From: Nicholas Lack [REDACTED]
Sent: 02 September 2019 12:06
To: Maria Tomalova <Maria.Tomalova@arun.gov.uk>
Subject: Planning Consultation on: BN/66/19/PL

Engineers Comments Regarding Surface Water Drainage

APPLICATION NO: BN/66/19/PL

Description of Works: Erection of 3 No dwellings.

APPENDIX 5 – Sewage Treatment Plant Details

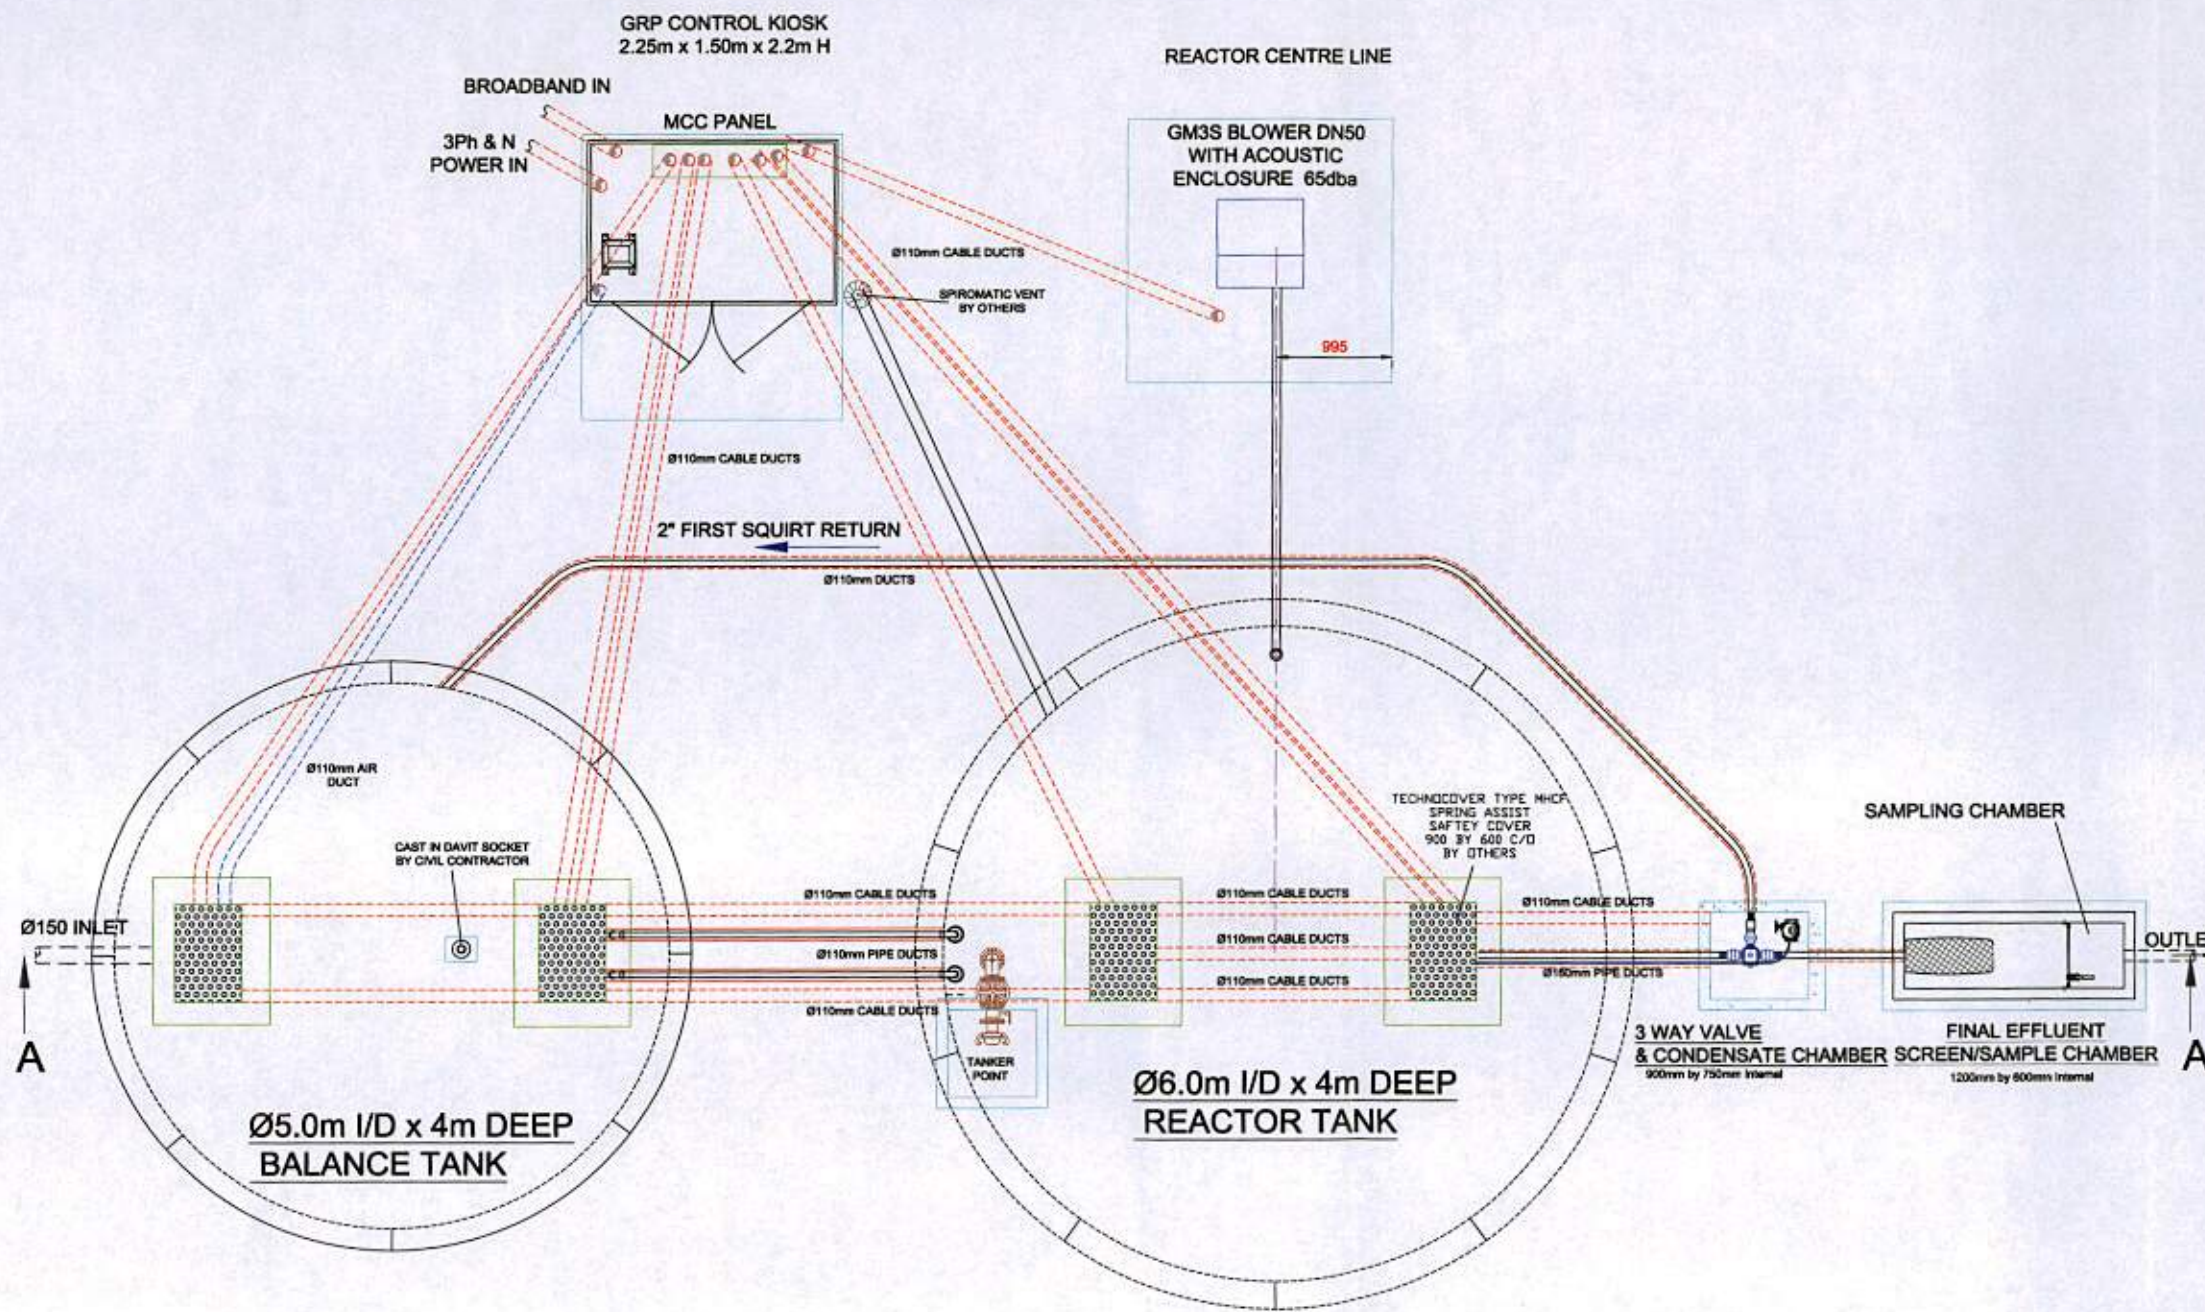
What we think has happened in relation to Laura Gibbons comments, and one of the residents is that originally our application site was earmarked for a sewerage treatment plant but this was never constructed as it was found to be feasible to connect all the houses to the existing foul water sewerage system directly. Perhaps they are citing out of date drainage plans?

It appears that the documents submitted in support of a discharge of conditions application (reference BN/25/14/DOC) for the wider site indicate that a foul water treatment plant is located in the area of the proposed development. Please can the applicant confirm if this is the case or not. Until such time as this confirmation is provided we object to the application.

In response to your enquiry; the applicant has conferred with Croudace Homes who verify that apart from one foul sewer crossing the site, which we are proposing to divert, nothing else exists below the site to affect our proposed development.
